Final Report - Corrections Required **Application No. DEPN-26-0068**

Description : single family residential development with optional ADU. 41 lots

Document Filename : DP Creekridge at Flying Horse Filing No 2.pdf

CREEKRIDGE AT FLYING HORSE
 FILE NO. 2
 DEVELOPMENT PLAN
 PRELIMINARY UTILITY & PUBLIC FACILITIES PLAN

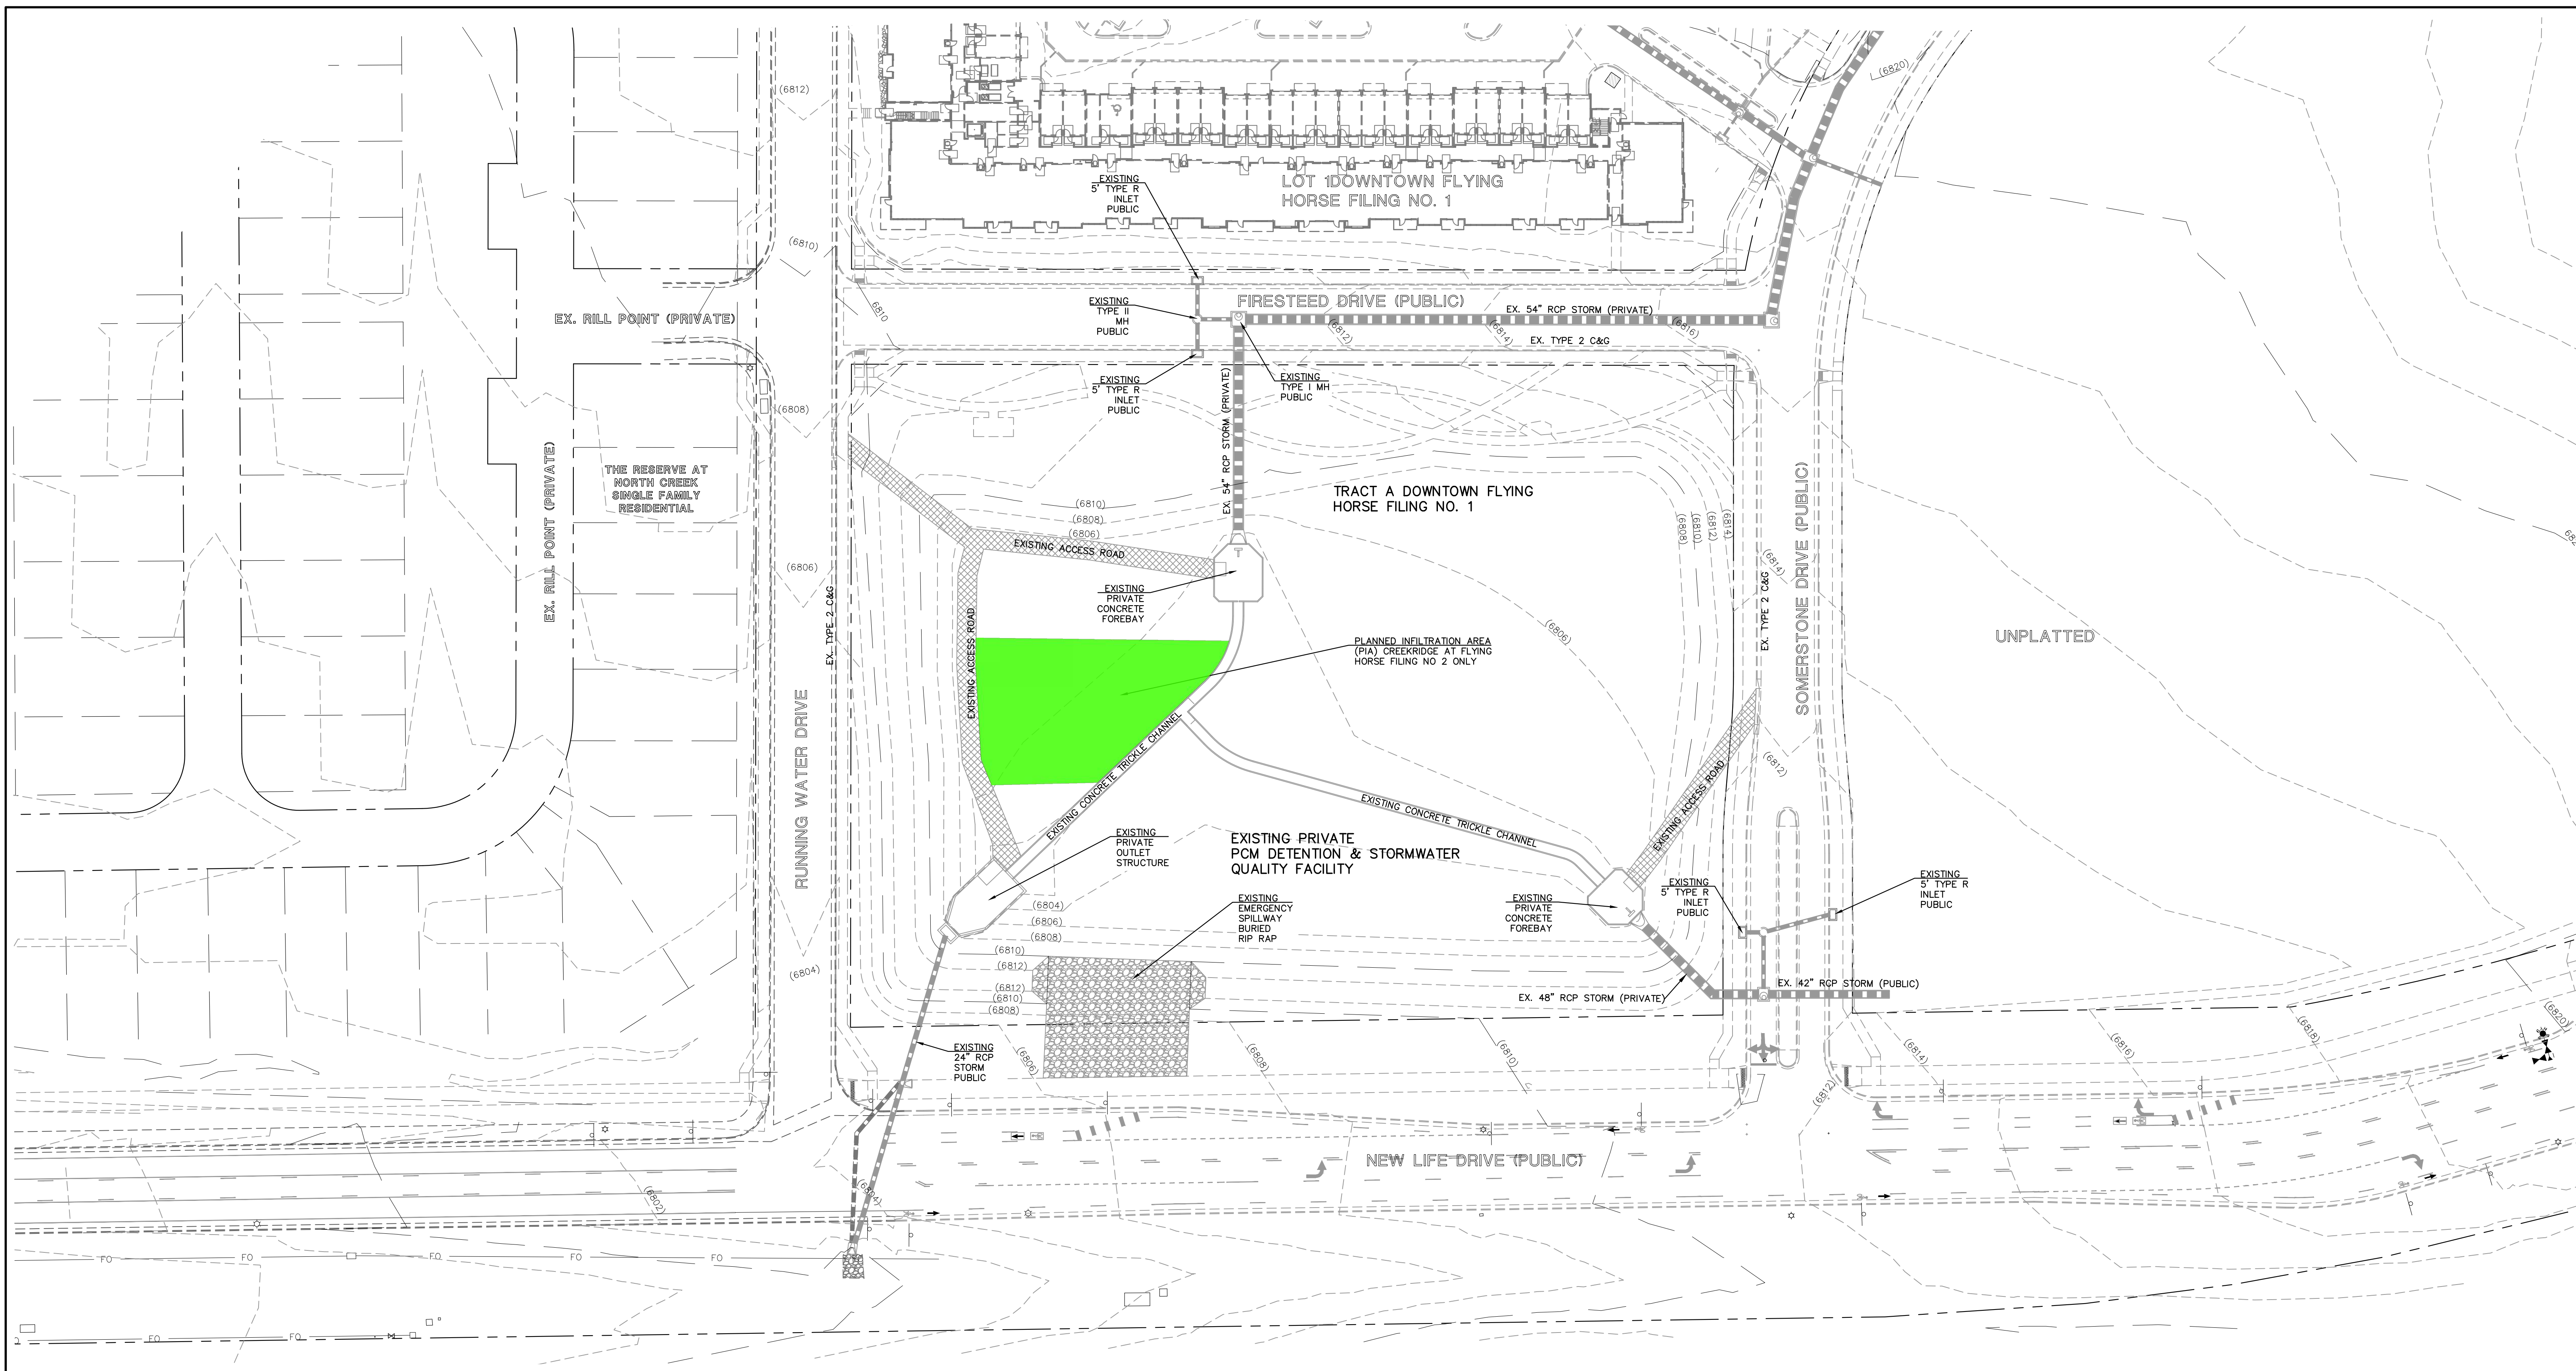
16	3	Hao Vo : City Engineering Dev Review	Please call out curb and gutter on InterQuest Pkwy.
18	2	Matthew Alcuran : Col Springs Utilities	Show gas main in center per GLESS A3-14 detail.
19	4	Matthew Alcuran : Col Springs Utilities	Add "and service lines" per WLESS and WWLESS
20	4	Matthew Alcuran : Col Springs Utilities	Show gas main in center of road per detail GLESS A3-14
21	4	Matthew Alcuran : Col Springs Utilities	Show conceptual location of transformers for CSU Electric Field Engineering to review for clearances.
22	4	Matthew Alcuran : Col Springs Utilities	Add note " Gas meters must be a minimum of 3-feet from doors, operable windows, or any vents or openings in walls."
23	4	Matthew Alcuran : Col Springs Utilities	Add note "CSU Field Engineer to determine final gas/electric meter, transformer, and service line locations. Contact Field Engineering at 719-668-4985 (Gas) or 719-668-5564 (Electric) with any questions."

25	7	Matthew Alcuran : Col Springs Utilities	Utility plan shows a proposed fire hydrant south of Lot 11. Clarify to ensure horizontal separation from trees.
26	7	Matthew Alcuran : Col Springs Utilities	Utility plan shows a proposed fire hydrant south of Lot 24. Clarify to ensure horizontal separation from trees.
1	1	Jason Jacobsen : Comcast	Comcast has no issues.
37	1	Caroline Miller : Planning	Please see Staff Note 00045 and remove Note 19 - the sidewalks within CreekrIDGE at Flying Horse No. 2 will be internal pedestrian connections, rather than Urban Trails.
38	1	Caroline Miller : Planning	CDI: Citywide Development Impact Fees for Police and Fire apply to all new and redeveloped residential and nonresidential development, per City Code 7.5.532. This development is applicable to CDI, and a School and CDI Fee estimate has been uploaded to this file for applicant review, with fees due at the time of building permit. This Fee estimate does not include integrated ADU Fee estimates. If there are questions or additional prior history that is applicable to this site for fee determinations, please reach out to reviewer. Fees are subject to change by time of payment.
